CITY OF ALBUQUERQUE

June 15, 2022

**RE: Homes Direct
601 San Jose Ave. SE
Grading & Drainage Plan
Engineer's Stamp Date: 05/06/22
Hydrology File: M14D004E**

Grading Plan

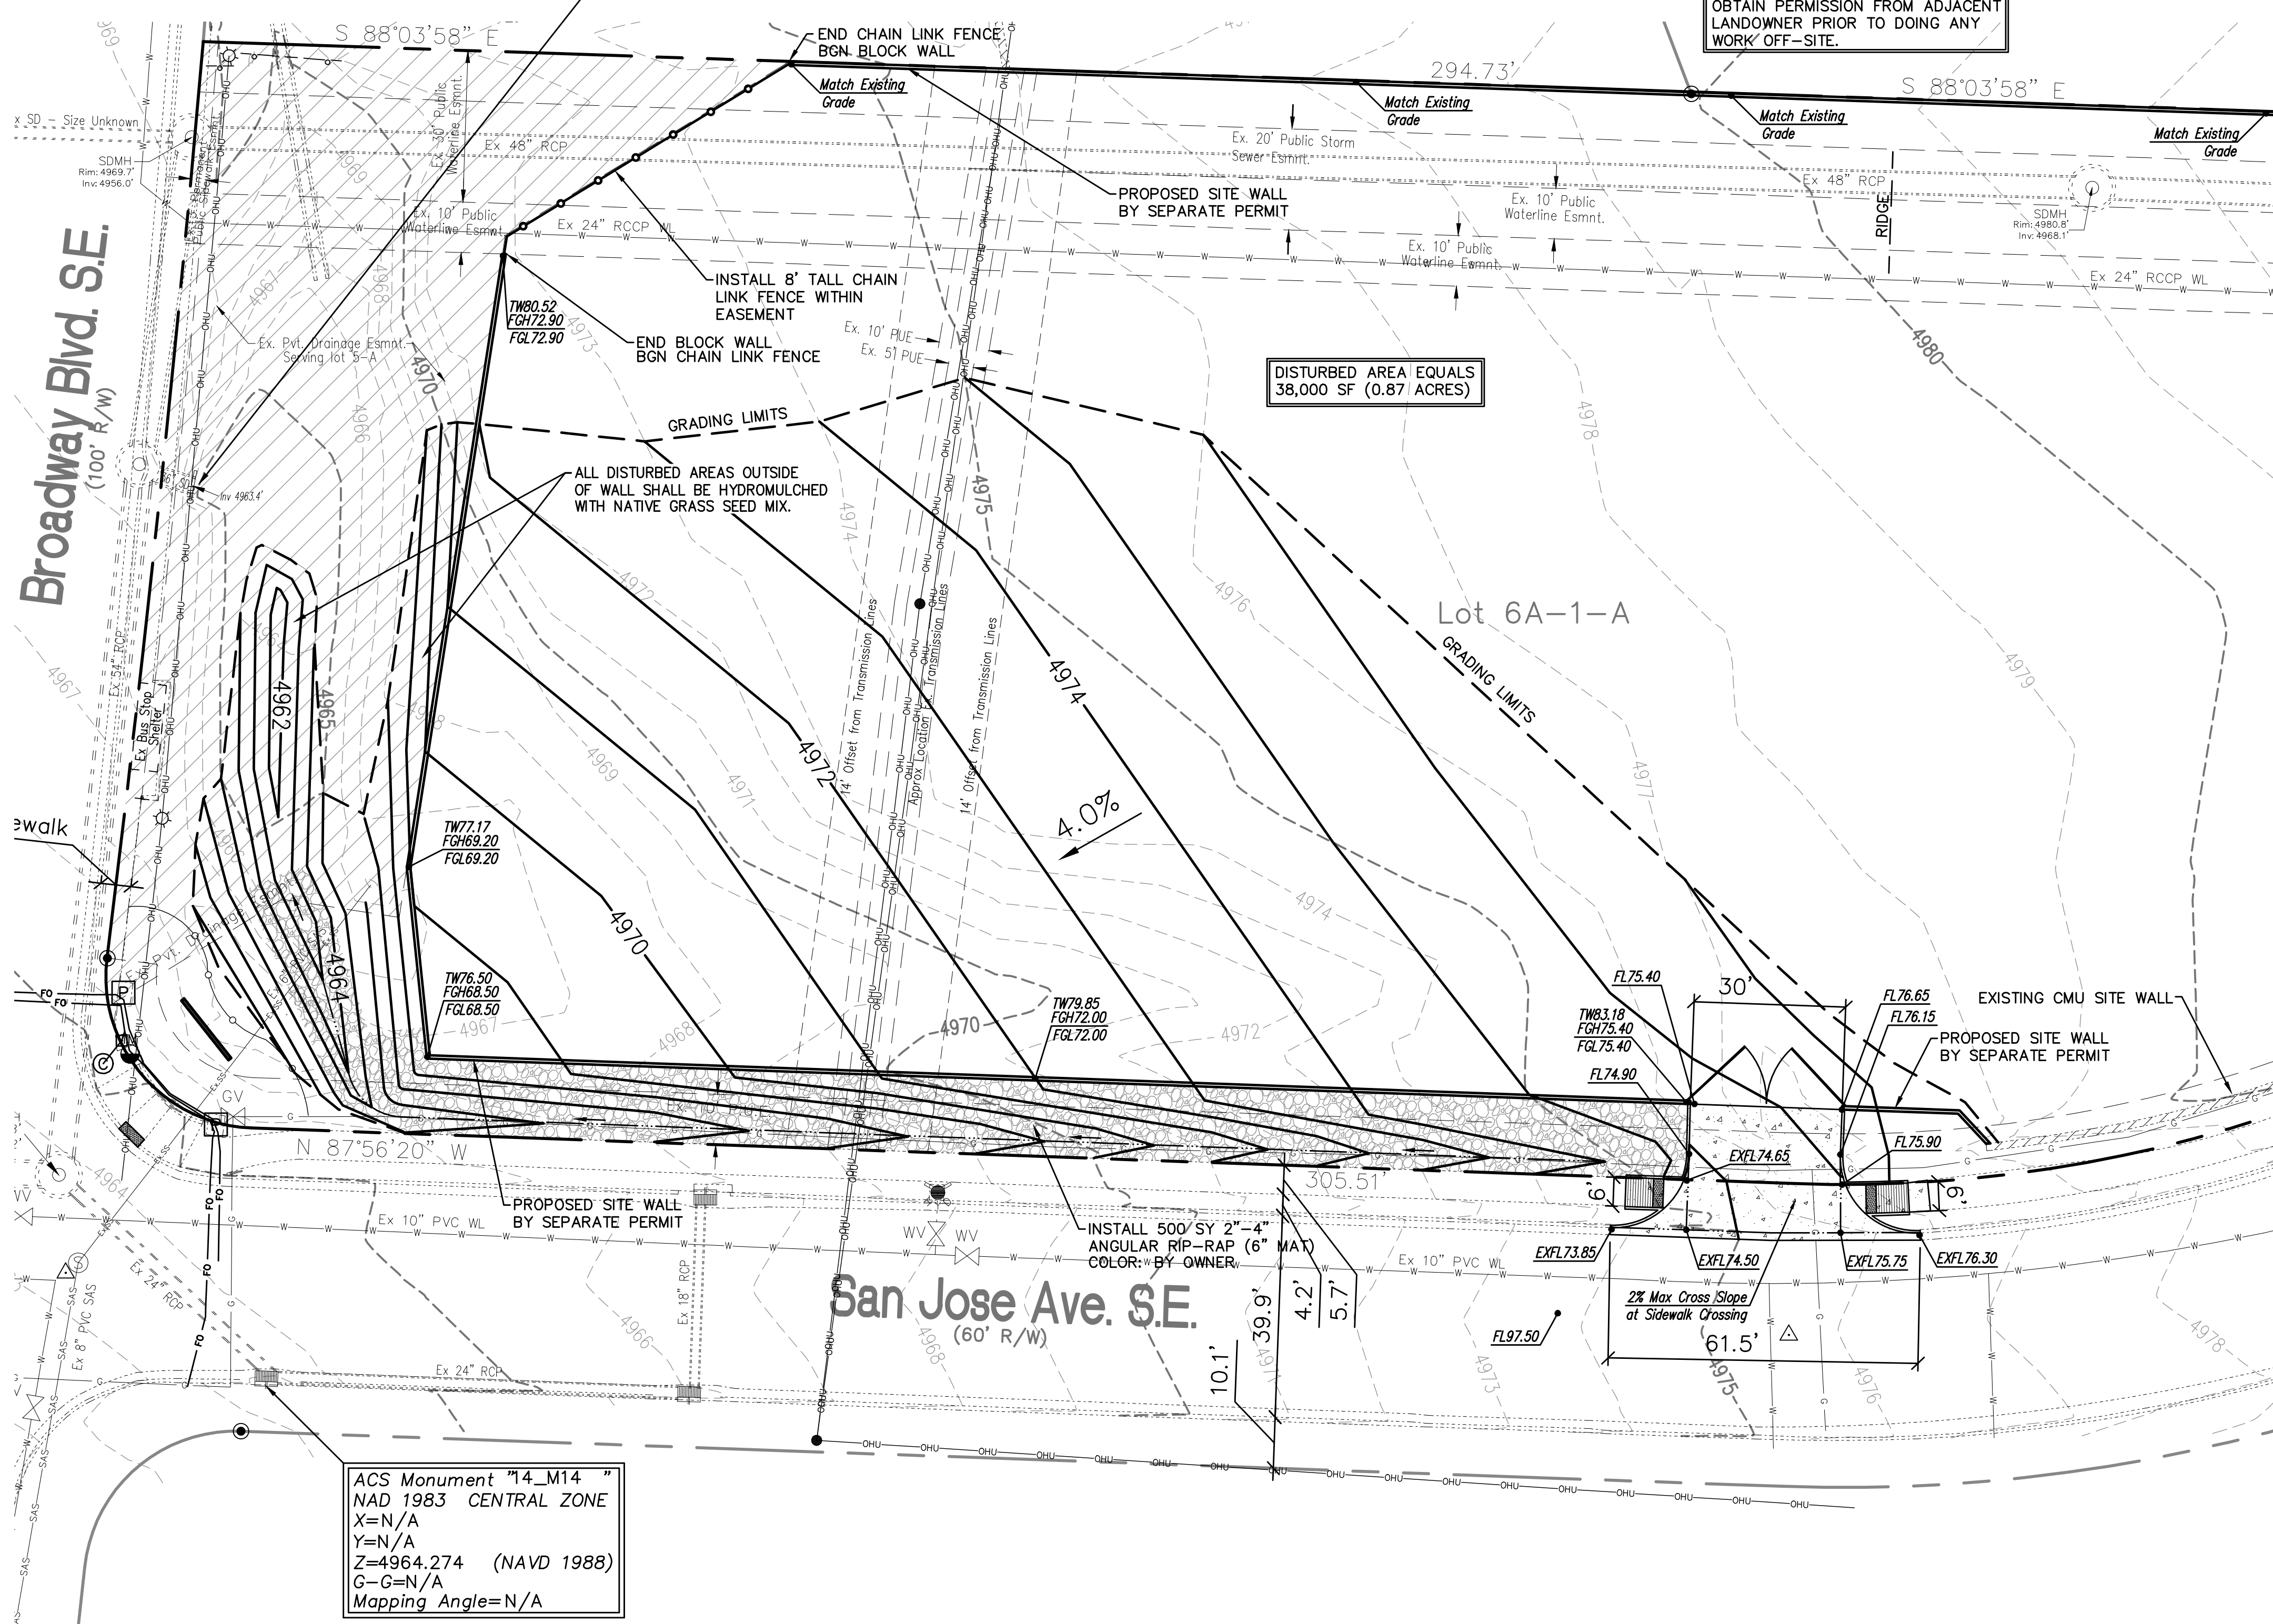
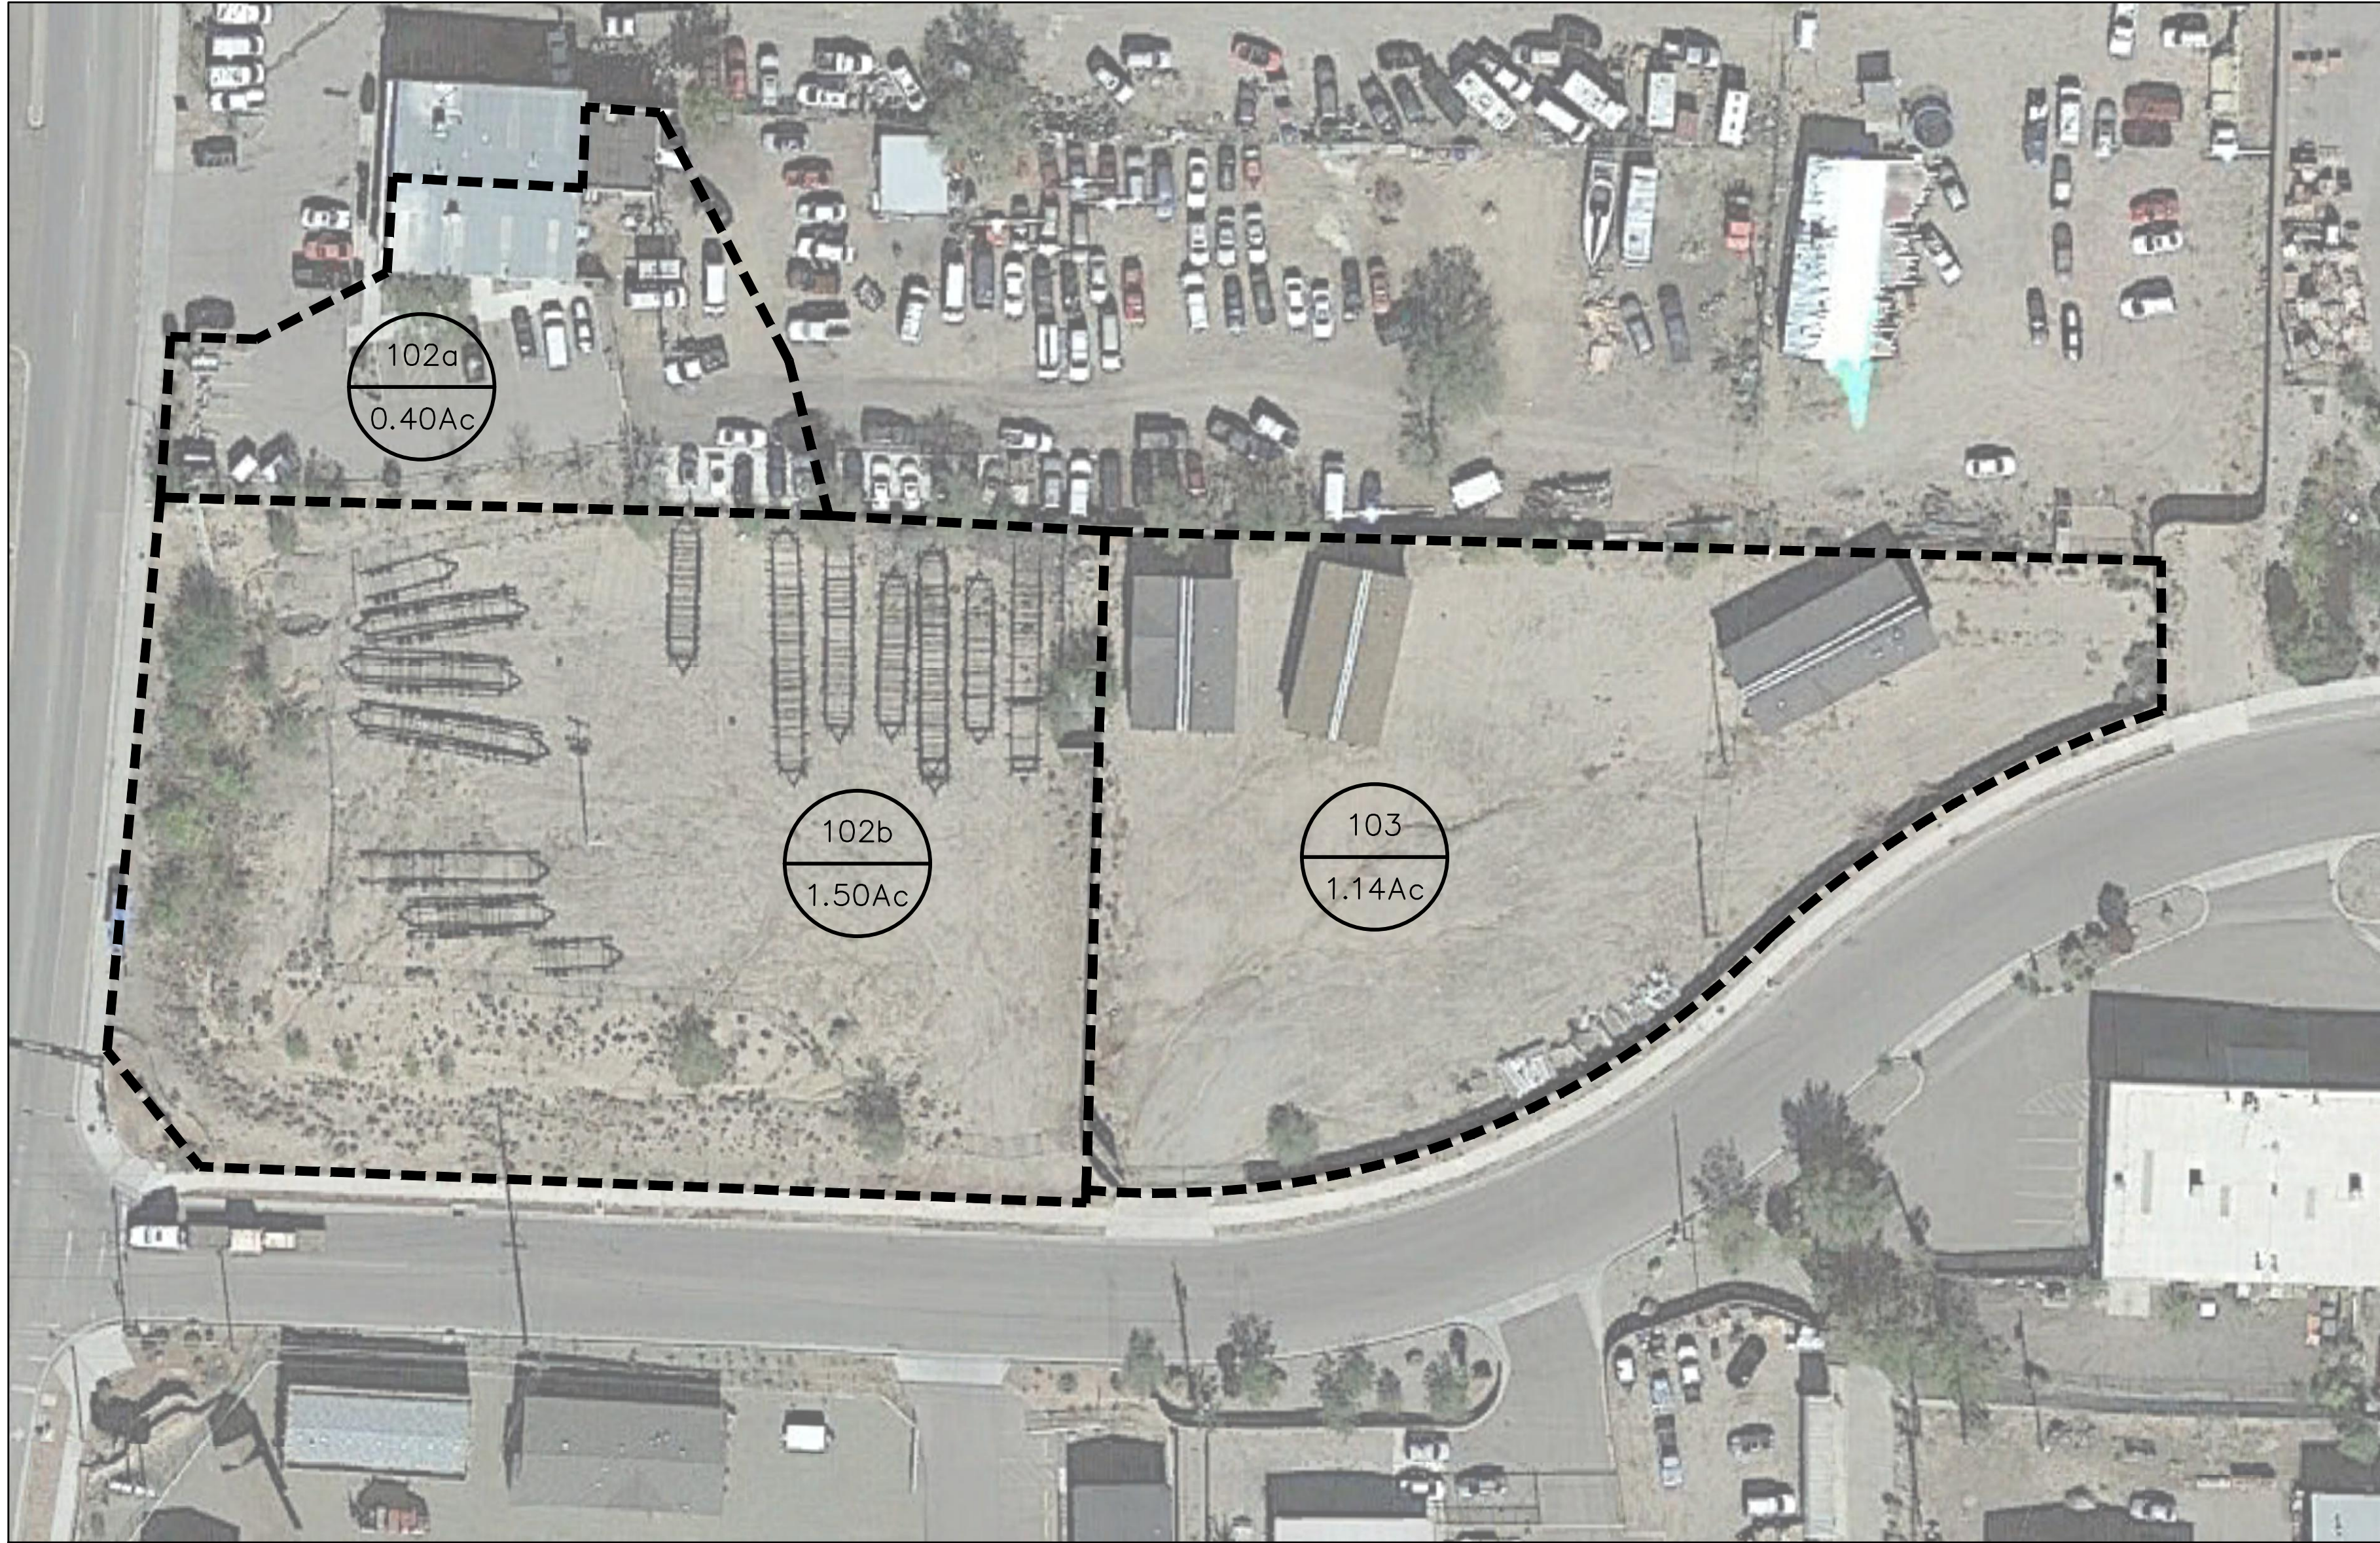
1. Please label the lot correctly. It is currently labeled as Lot 6A-1 & Lot 6A-2.
2. Since this property has been replated, the Legal Description also needs to be corrected to match this recent filing.

3. Please provide the top of wall, existing and proposed grades on both sides of the proposed garden wall. Also, please provide sections through all external boundaries showing proposed garden walls, type of footer, property/ROW lines, existing and proposed grades.

4. Please note that there cannot be any walls built within the City's Public Storm Sewer Easement and I am sure that Water Authority has similar restrictions within their Public Water line Easements. I would suggest either just installing a chain link fence or relocation the wall along the southern side of the southern most Public Waterline Easement.

7. Please label the shaded existing private drainage access easement for Lot 5A.
8. Please note that Lot 5A was designed under M14D012G by Mark Goodwin & associates with engineering stamp date of 10/14/04. 0.28 ac of Lot 5A is allowed to discharge into the detention pond on Lot 6. This area has a discharge of 0.98 cfs and an allowable discharge rate of 0.47 cfs. Please show the off-site discharge from Lot 5A.

Drainage Plan

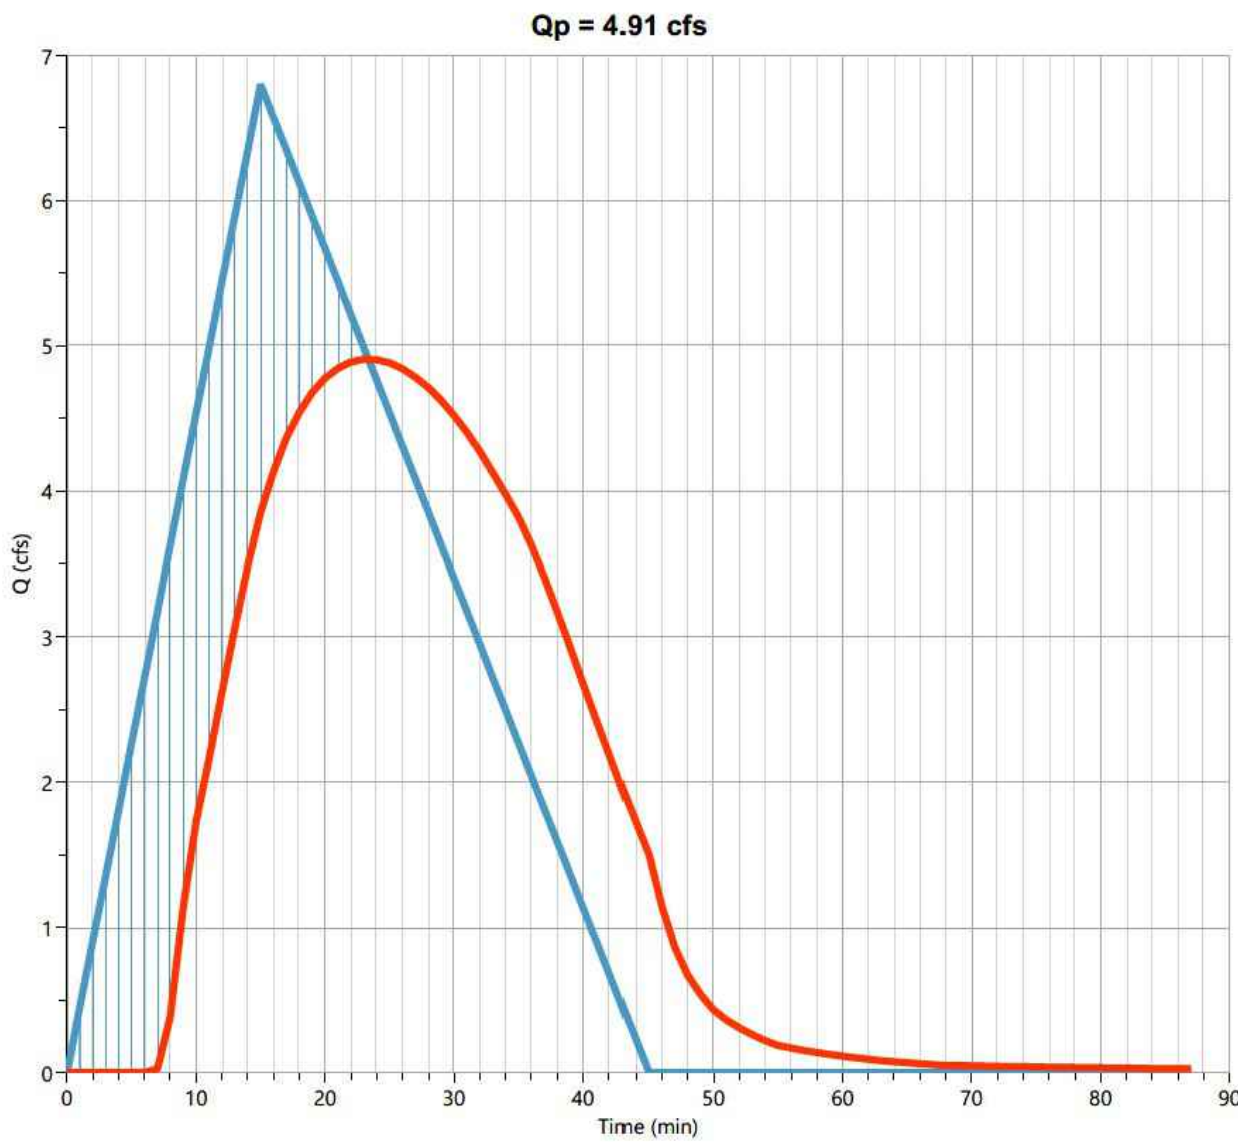
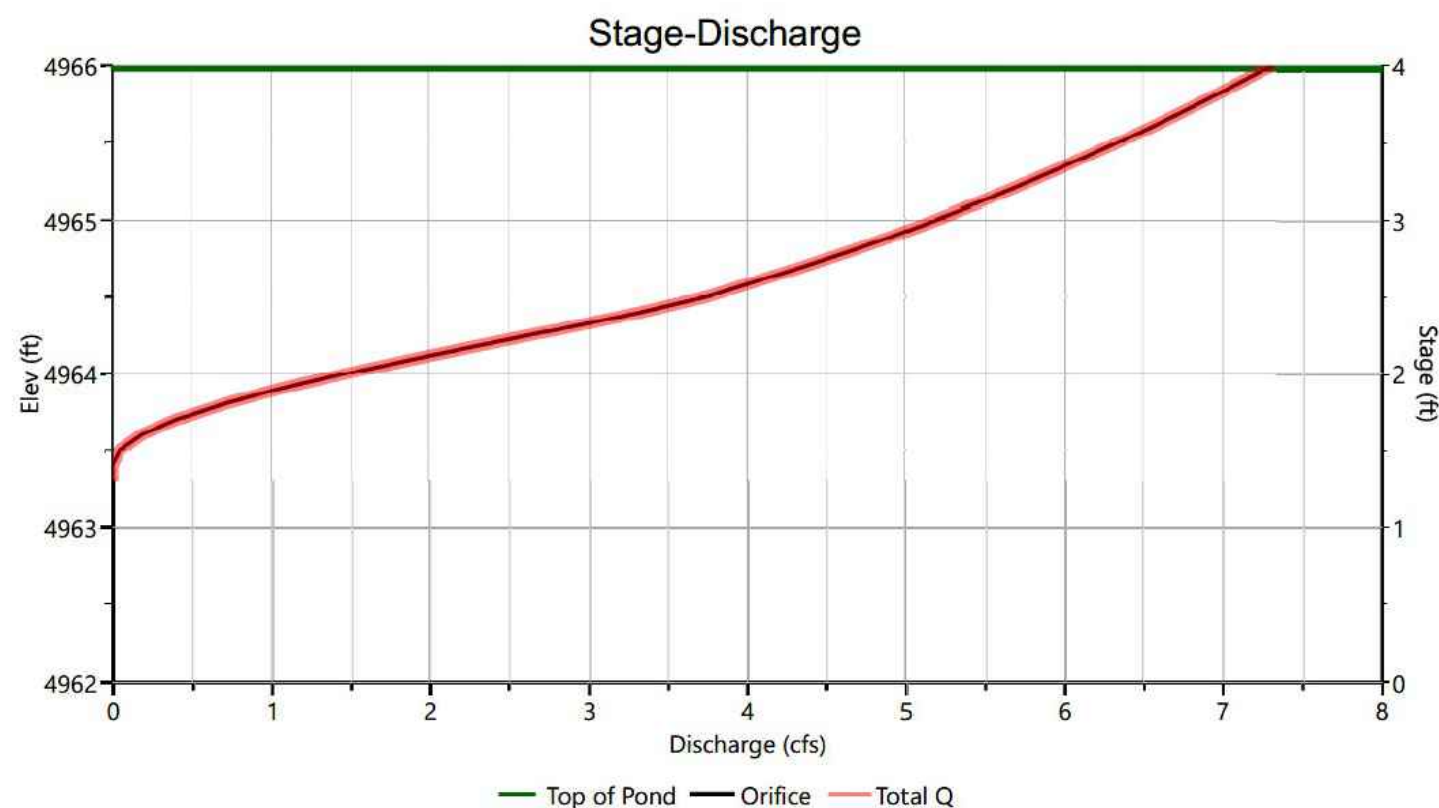
5. Please use the procedure for 40 acre and smaller basins as outlined in Development Process Manual (DPM) Article 6-2(a). Please provide both the existing conditions and proposed conditions for the 100 year-6 hour storm event.

6. Under Existing Conditions, please states, "In accordance with the Broadway Industrial Center Master Drainage Management Plan by Mark Goodwin & Associates with Engineer's stamp date 1-26-99 this property has a limited discharge of 1.67 cfs/ac."

9. Please provide the calculations for the reshaping of the detention pond. Also, there should be an existing orifice plate within the outfall pipe or manhole. This will need to be verified. If there is not one, then an outfall structure will need to be designed and installed to limit the discharge to 5.08 cfs. (portion of Lot 5A – $1.67 \text{ cfs/ac} \times 0.28 \text{ ac} = 0.47 \text{ cfs}$) + (Lot 6 – $1.67 \text{ cfs/ac} \times 2.76 \text{ ac} = 4.61 \text{ cfs}$).
